ENG-SKP22004-R3-TIS.pdf Markup Summary

<div>(LSC #322444U)</div> <div>October 26, 2022</div> <div>SKP-22-004</div>	<div>Subject: Text Box</div> <div>Page Index: 1</div> <div>Date: 12/9/2022 1:45:41 PM</div> <div>Author: dsdrice</div> <div>Color: </div> <div>Layer:</div> <div>Space:</div> <div>Page Label: Sterling Ranch MTIS Cert Page</div>	<div>SKP-22-004</div>
---	---	-----------------------

Traffic Analysis Zones
Sterling Ranch

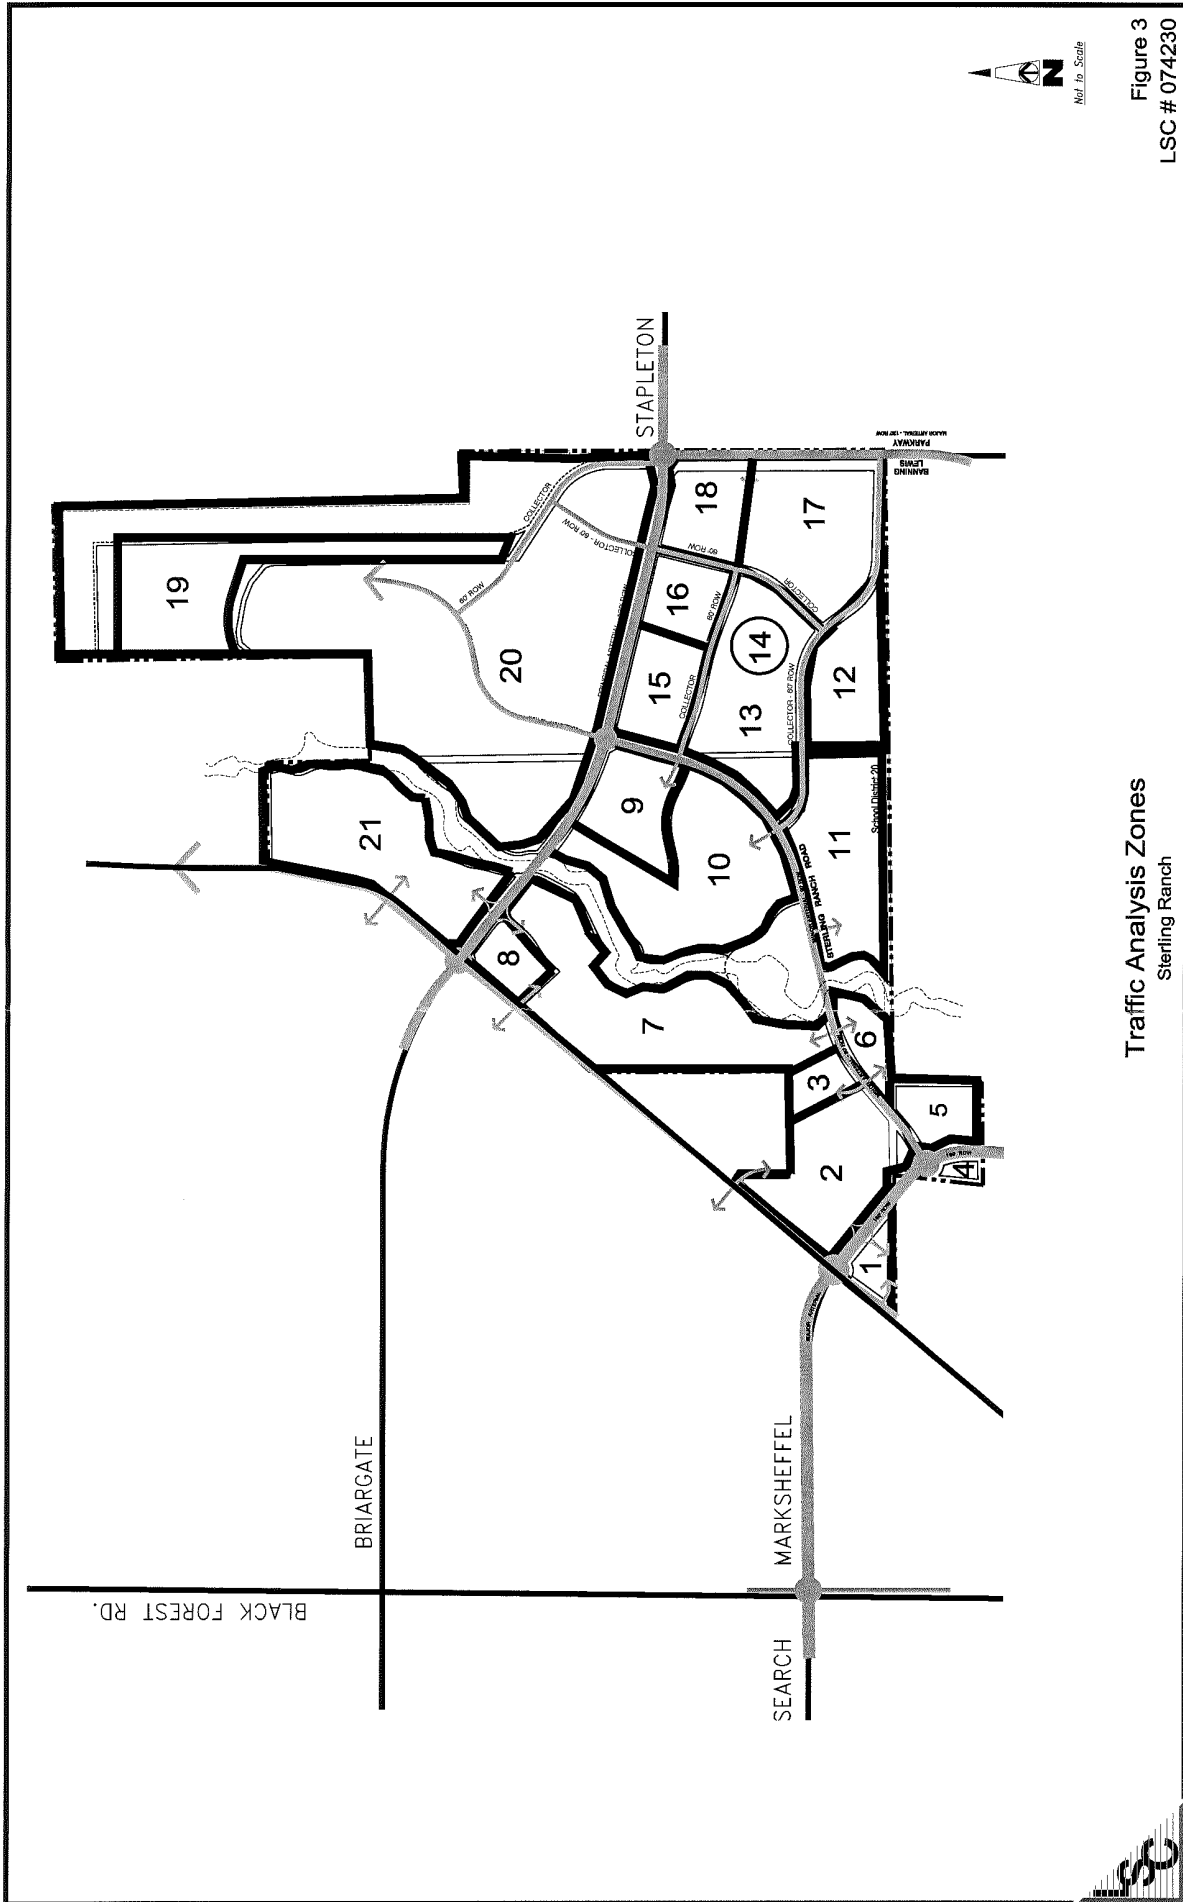
Why is there no trip generation for this land use?

Trip generation should be evaluated for each TAZ shown here.

Trip generation should be evaluated for each TAZ shown here.
